Our Case Number: ABP-319843-24

An
Bord
Pleanála

Date: 10 February 2025

Re: Proposed development for a Facility Centre for Water Based Activities.
Magherabeg Beach, Castlegregory, in the townland of Magherabeg, Co. Kerry.

DRAWING NUMBER: 23173 - MWP - 00 - 00 - DR - A - 0420	REV: P01
---	----------

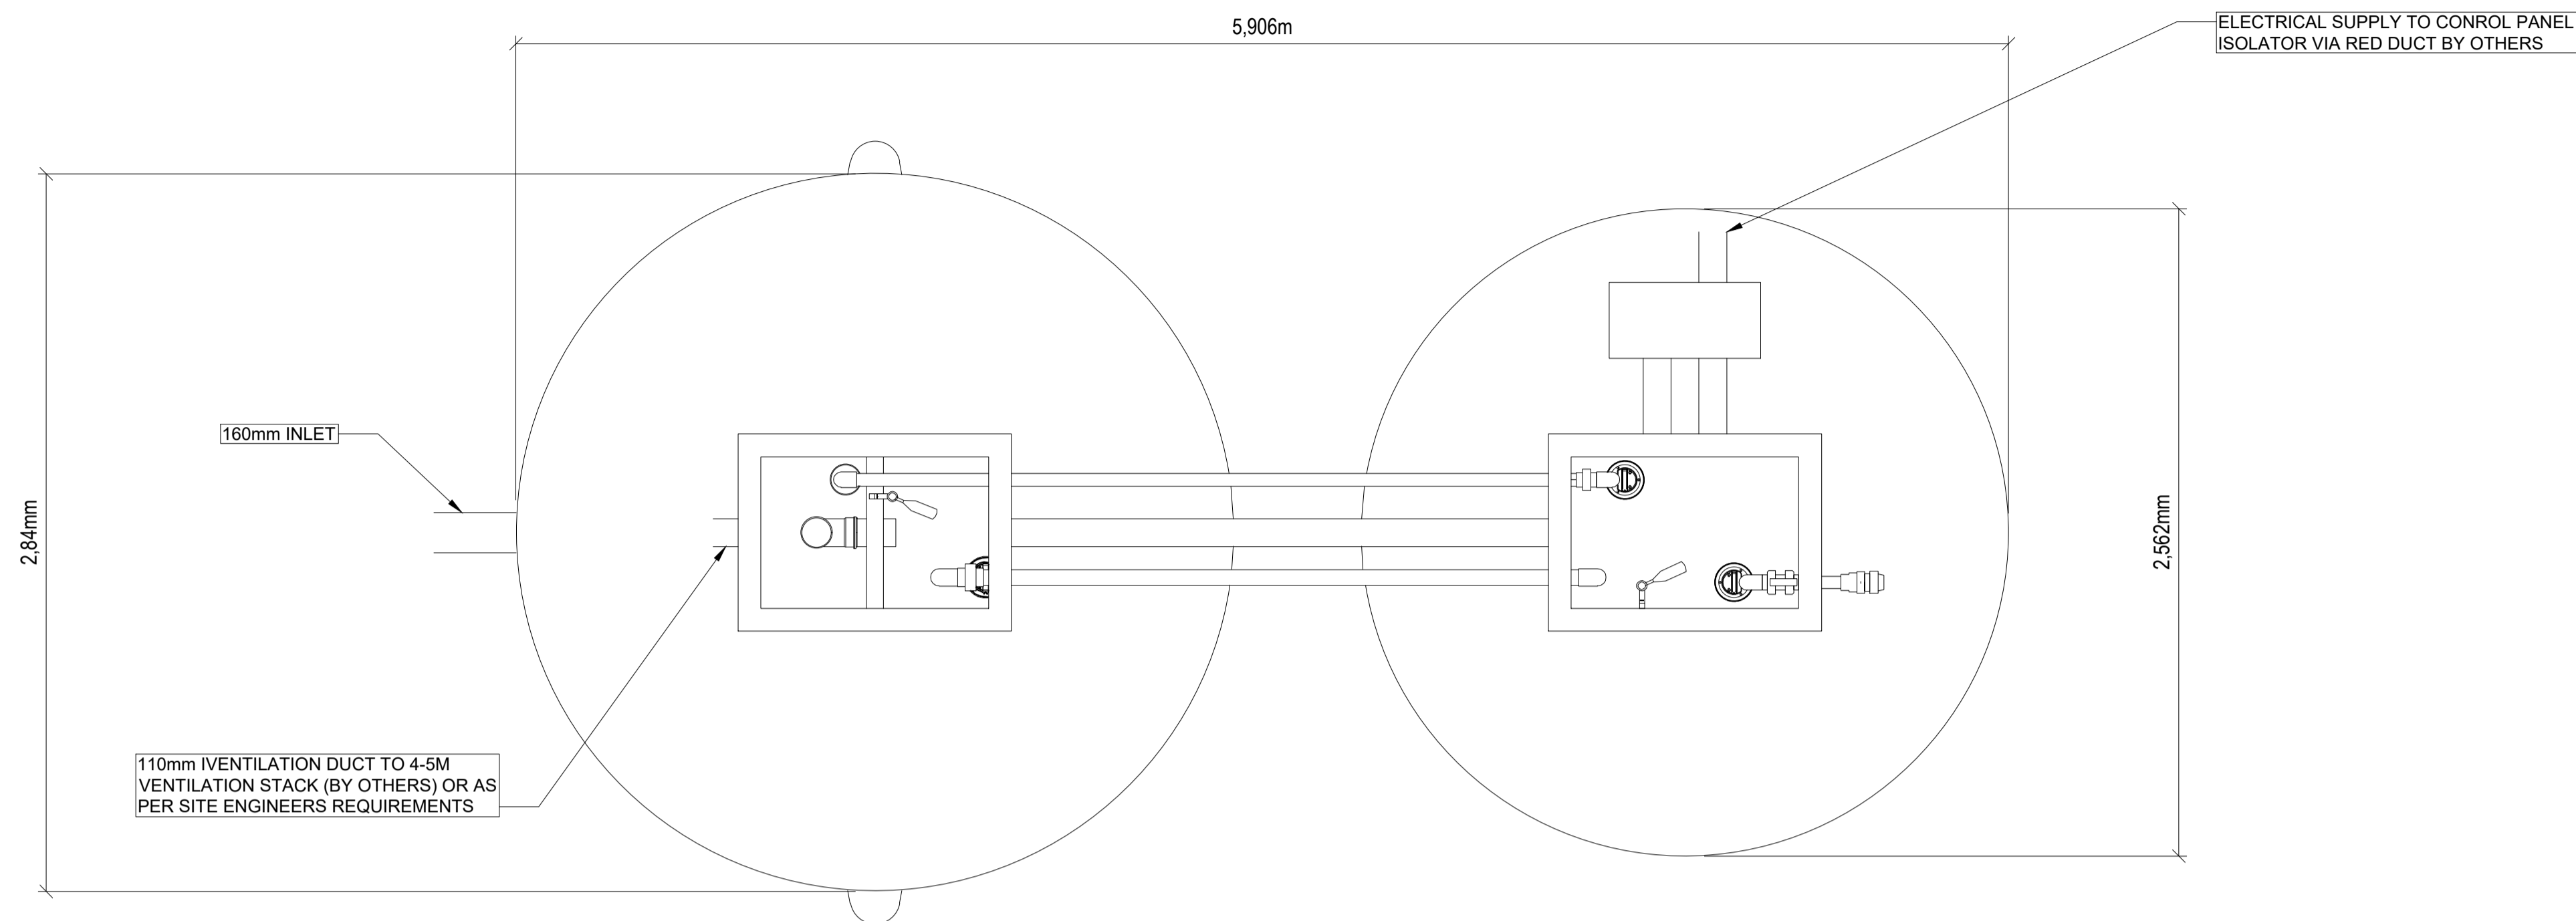
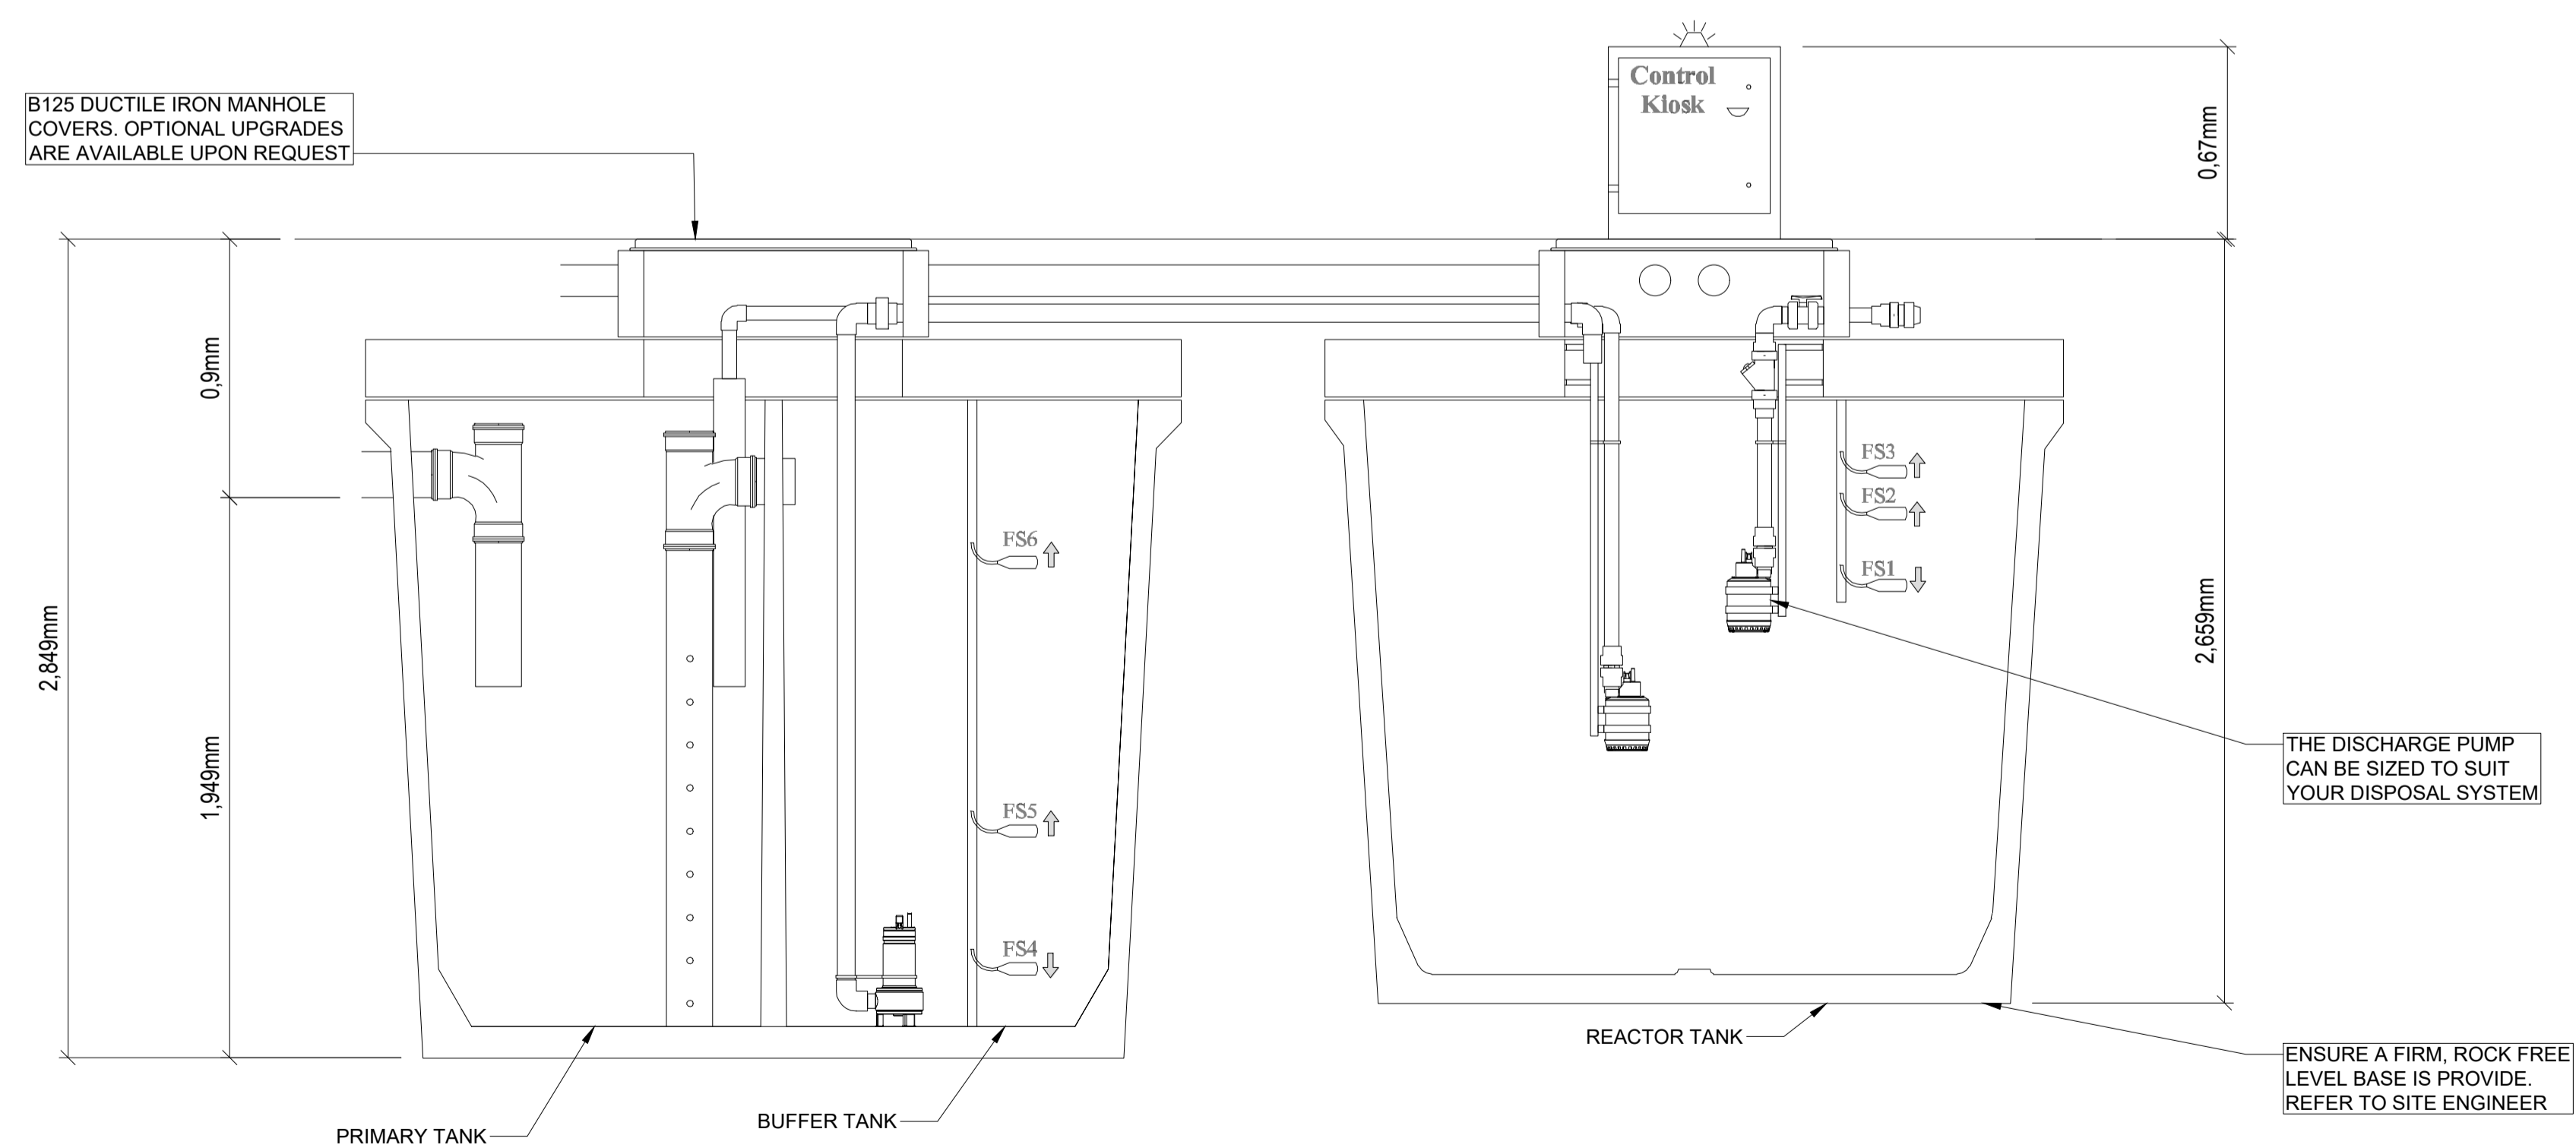
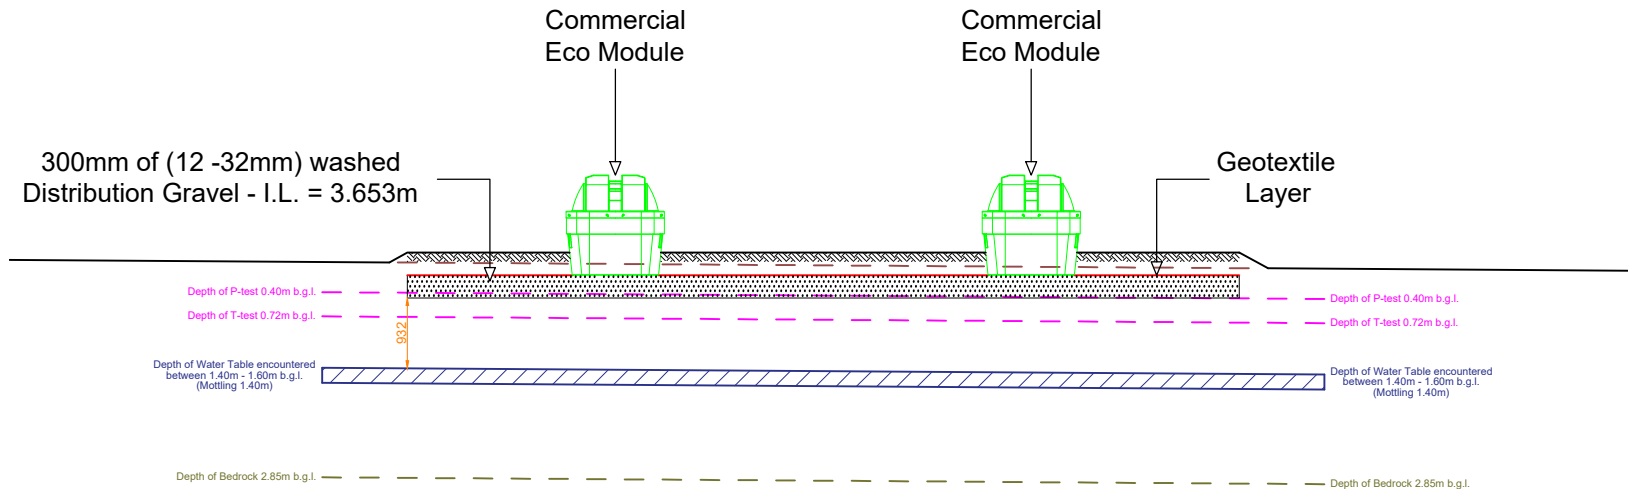
Ground elevation levels are absent from the submitted site layout drawings and therefore it is not clear what the changing levels are and the differing levels between the site entrance and the disabled access ramp. Likewise, with regard to the wastewater treatment plant, the relationship in level between the facility producing the wastewater and the treatment facility receiving the wastewater is also not clear. While noted that the Wastewater Treatment System document does provide invert levels on the Cross Sections (23173 MWP 00 00 DR A 0420) on page 40/41, there is no way of cross referencing these with actual ground levels.

- i. Submit an updated site layout plan clearly showing all ground elevation levels and in addition the location of the proposed construction compound.

Figure 5. Proposed site layout (extract) (refer to MWP Drawing No. 23173-MWP-00-01-DR-C-0100-P02)

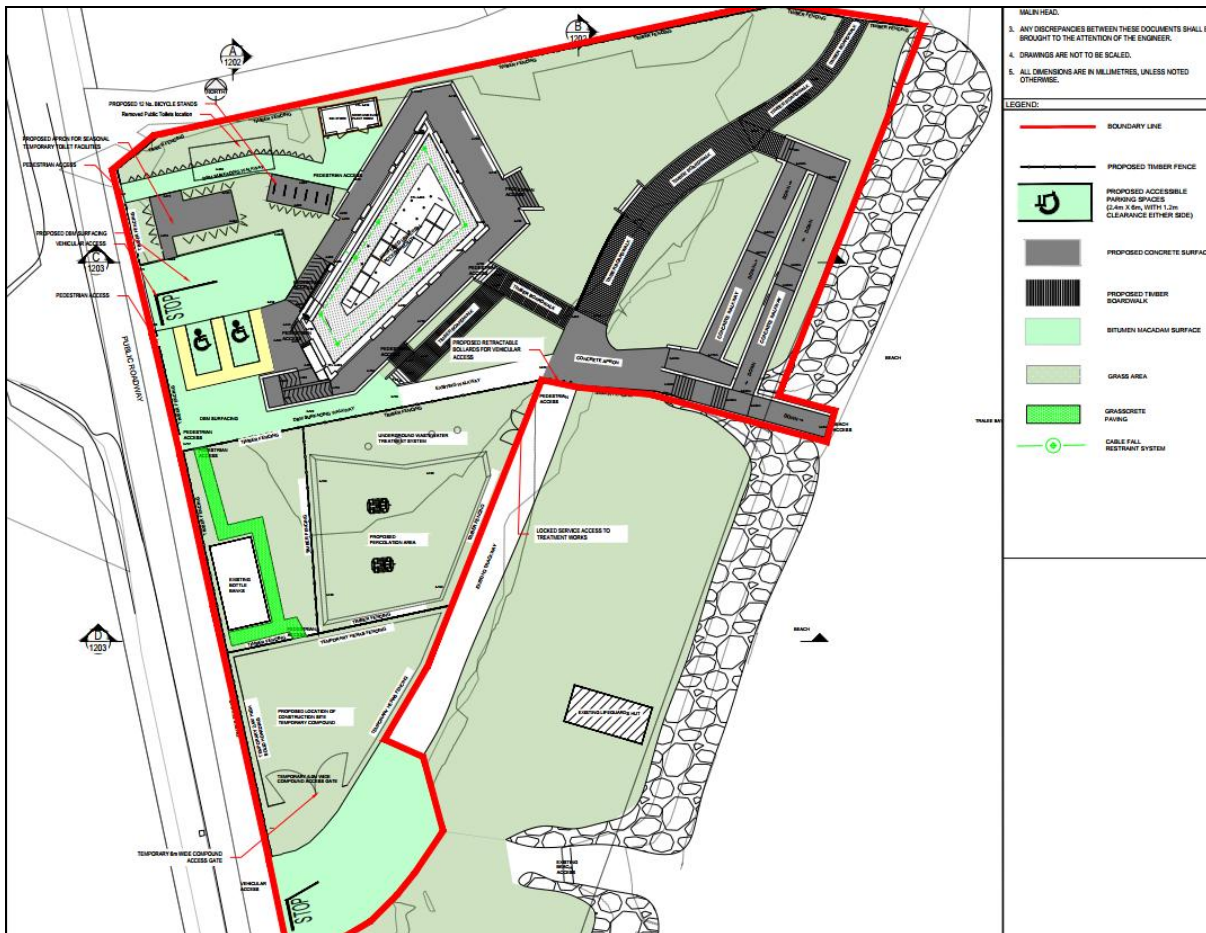
There would also appear to be discrepancies on some of the drawings submitted and inconsistencies between those drawings provided with the application and those contained within the submitted Natura Impact Statement (NIS).

In summary, there are several conflicting statements around wastewater and grey management in the NIS regarding the discharges from the site.

- i. Provide clarification and consistency across all documents;
- ii. Provide a tailored CEMP to address those details referred to in the NIS.
- iii. Address those points previously raised under **Request Point 1. Part iv** of this FI request above in relation to any updates required to Drawing no. 23173-MWP-00-01-DR-C-0105 and Drawing no. 23173-MWP-00-01-DR-C-0101.
- iv. Having regard to the above, the NIS should be updated accordingly (including potential impacts from the provision of a temporary construction compound).
